Please ask for: Ms Iqraa Malik
Email: iqraa.malik@terraquest.co.uk
Telephone: 0121 234 1390
Our Ref: FP/206/21/HH
Your Ref:
Date: 23rd September 2021

Application for Planning Permission for Works or Extension to a Dwelling

Development: Single storey front porch/garage extension
Location: 10 Old Manor House Gardens Felpham PO22 8QR

Existing Ground Floor Plan - 1:50

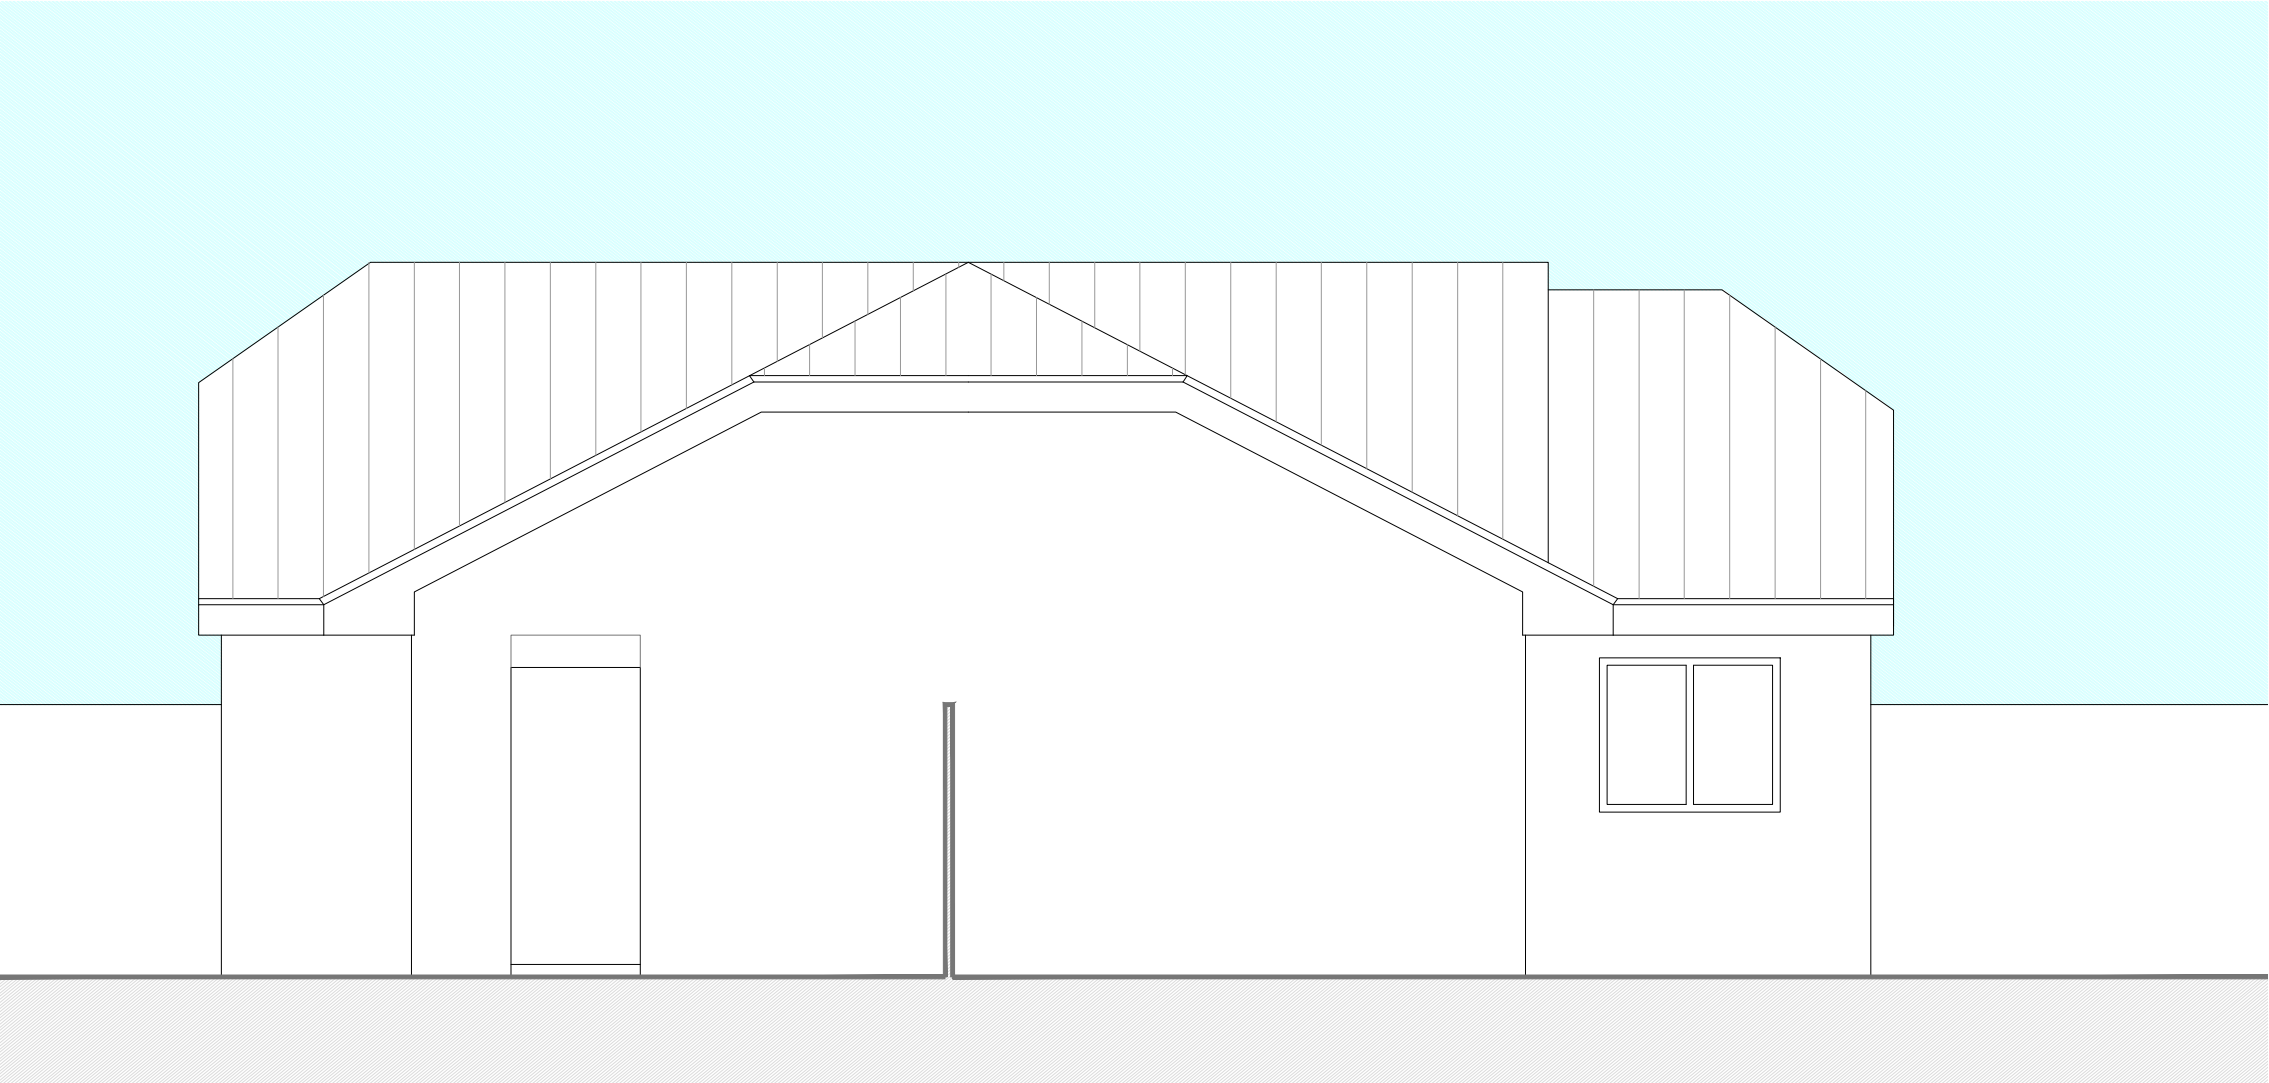
The door on the existing south elevation is missing from the existing ground floor plan. Please amend.

Title
Proposed Block Plan

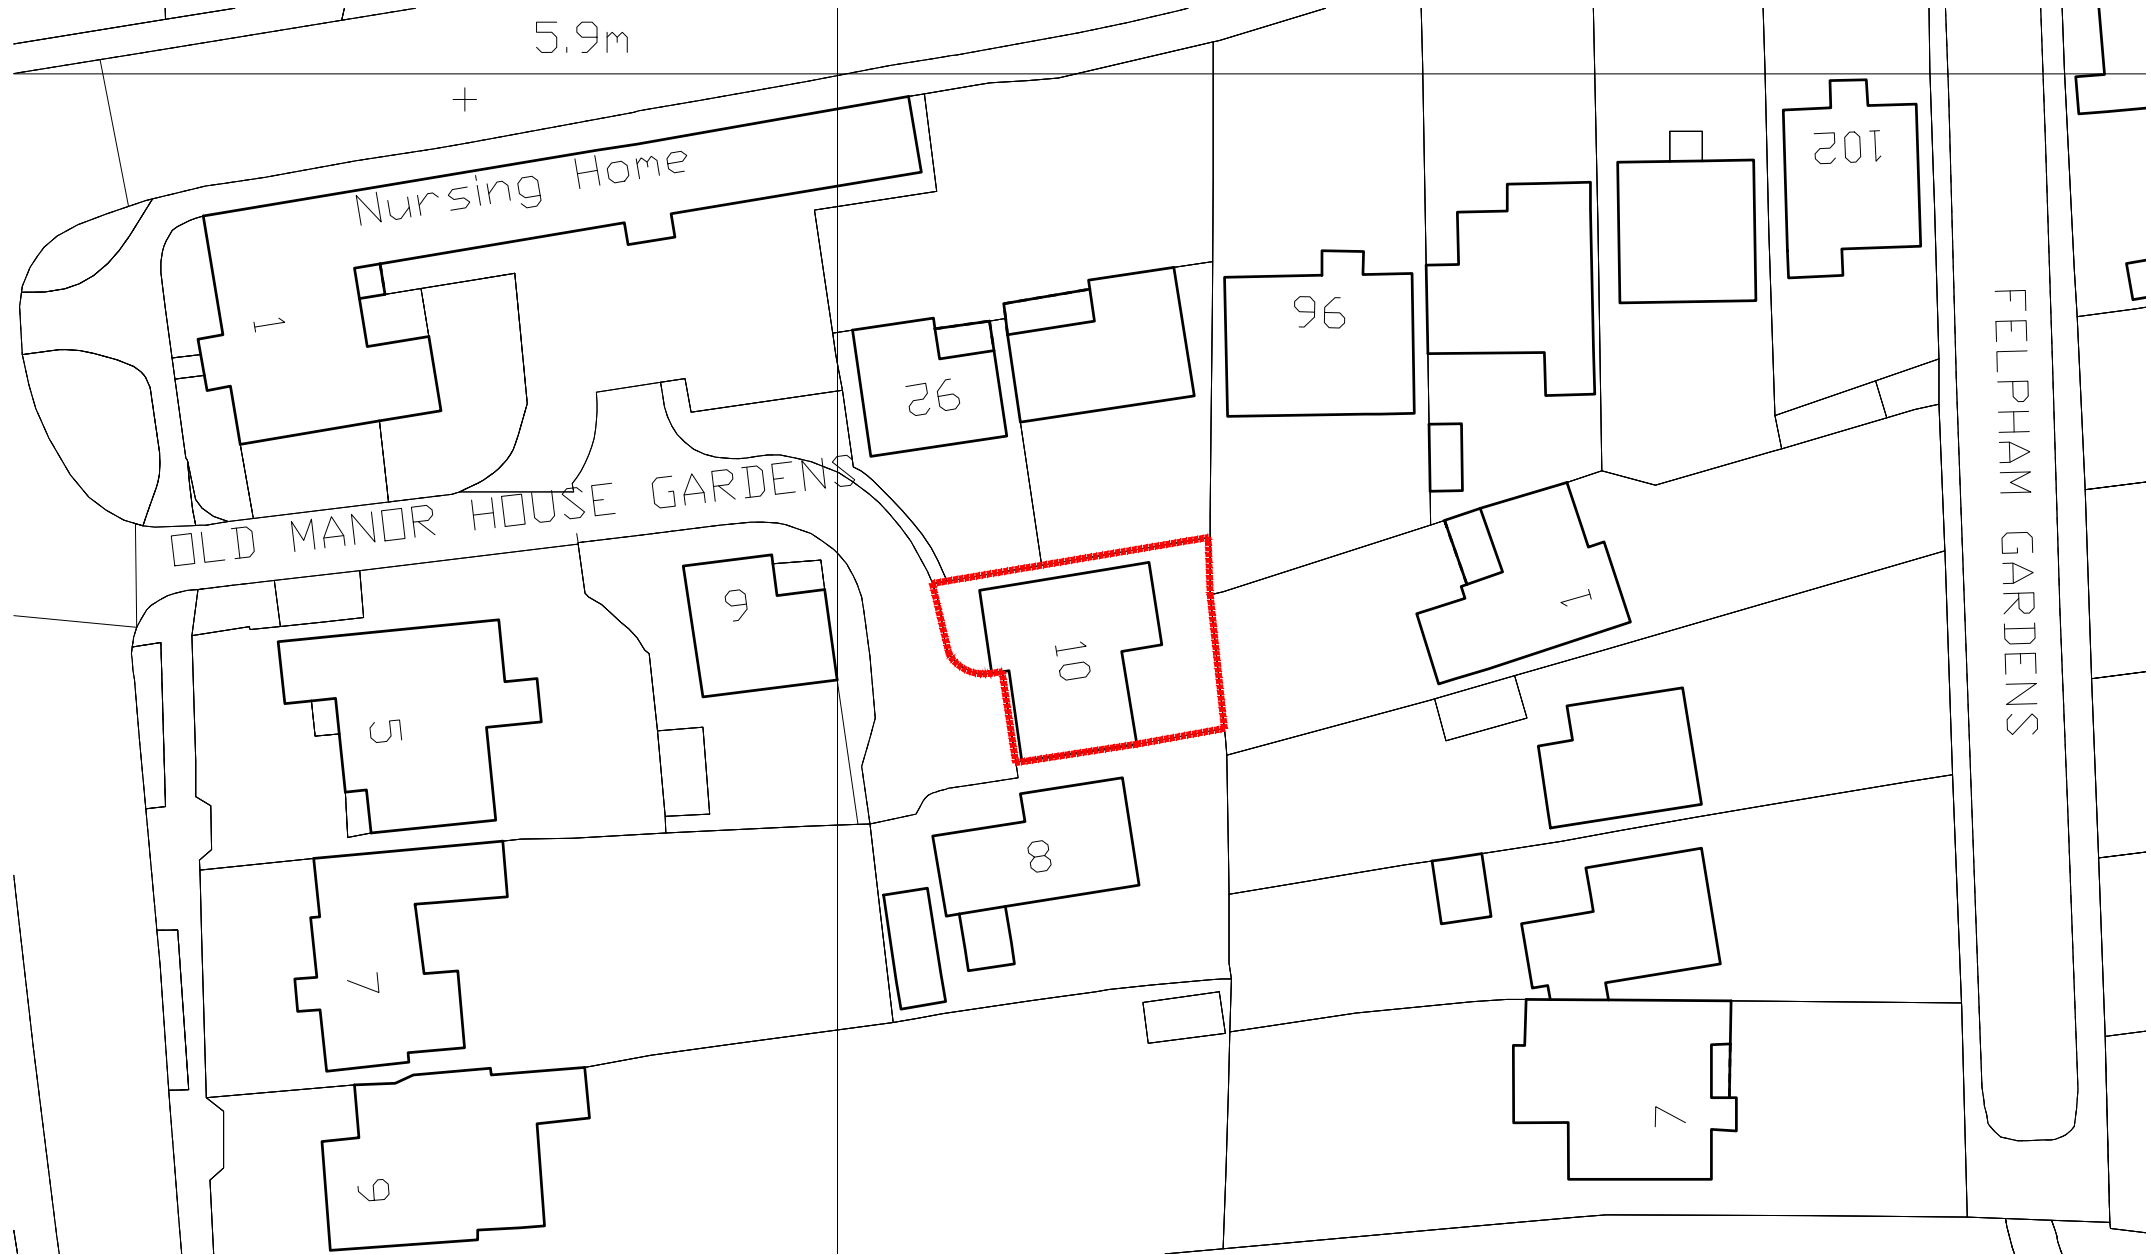
You are required to have dimensions from the proposed extension(s) to all site boundaries. Please amend.
